## DEPARTMENT OF PUBLIC WORKS

### MEMORANDUM

**TO:** All Staff  
**FROM:** Public Works Plan Review Team  
**DATE:** November 17, 2025- UPDATE January 15, 2026  
**SUBJECT:** BL-25-00019 M&M Lowe Family LLC.

WPA ROAD

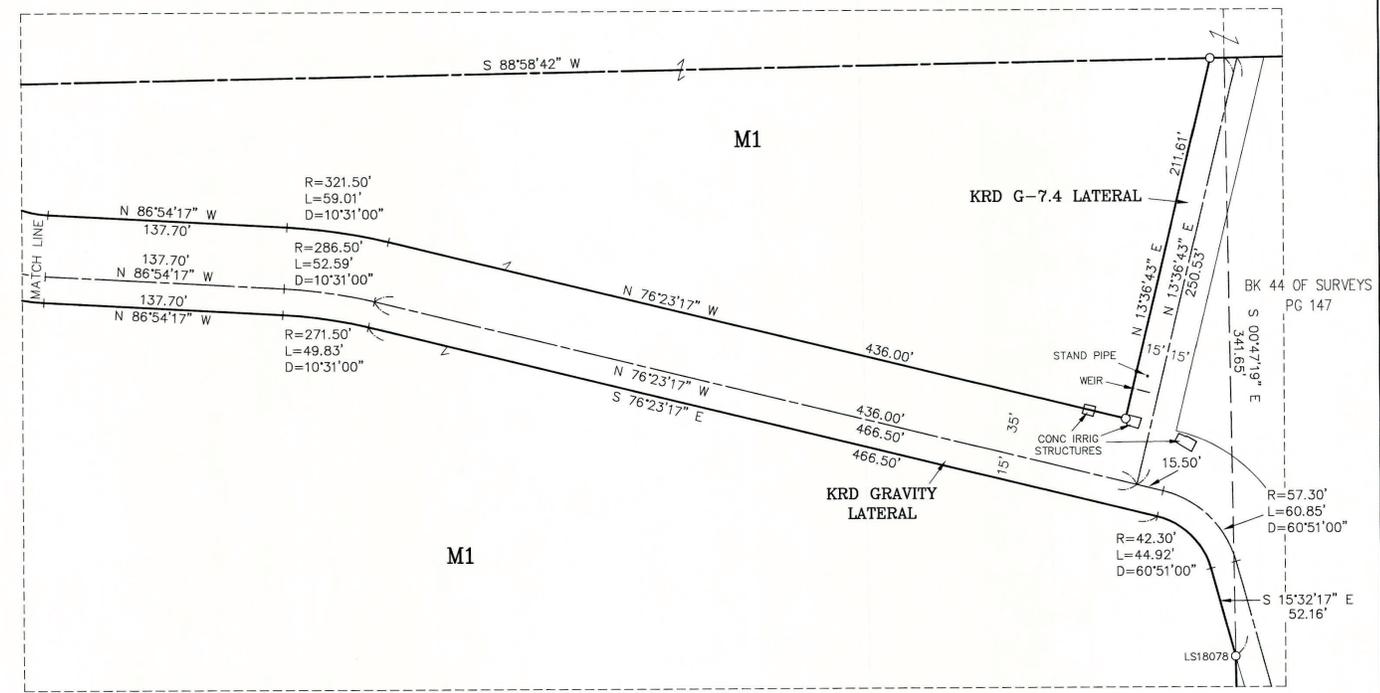
<p>2. Please label WPA Road as a county road.</p> <p>3. Per available aerial imagery, there are structures located South of the KRD Turbine Lateral near the East line of Parcel M1 and near the West line of Parcel M1. These should be shown on the map, or confirmation that these have been removed.</p> <p>4. Sheet 7 contains dimensions that may be unclear after scanning, due to touching property corner symbols. (3 occurrences).</p>
<b>TRANSPORTATION CONCURRENCY</b>	<p>Updated 11/20/2025</p> <p>Of Note:</p> <p>No transportation management application will be required of project as presented. Future development may be subject to concurrency requirements. (KAH)</p> <p>A concurrency evaluation and determination shall be required for all development applications in which the proposed development is projected to have an impact upon the transportation corridor or intersection.</p> <p>Developments generating 41 or fewer daily trips are exempt from the TIA and concurrency evaluation requirements. (KAH)</p>
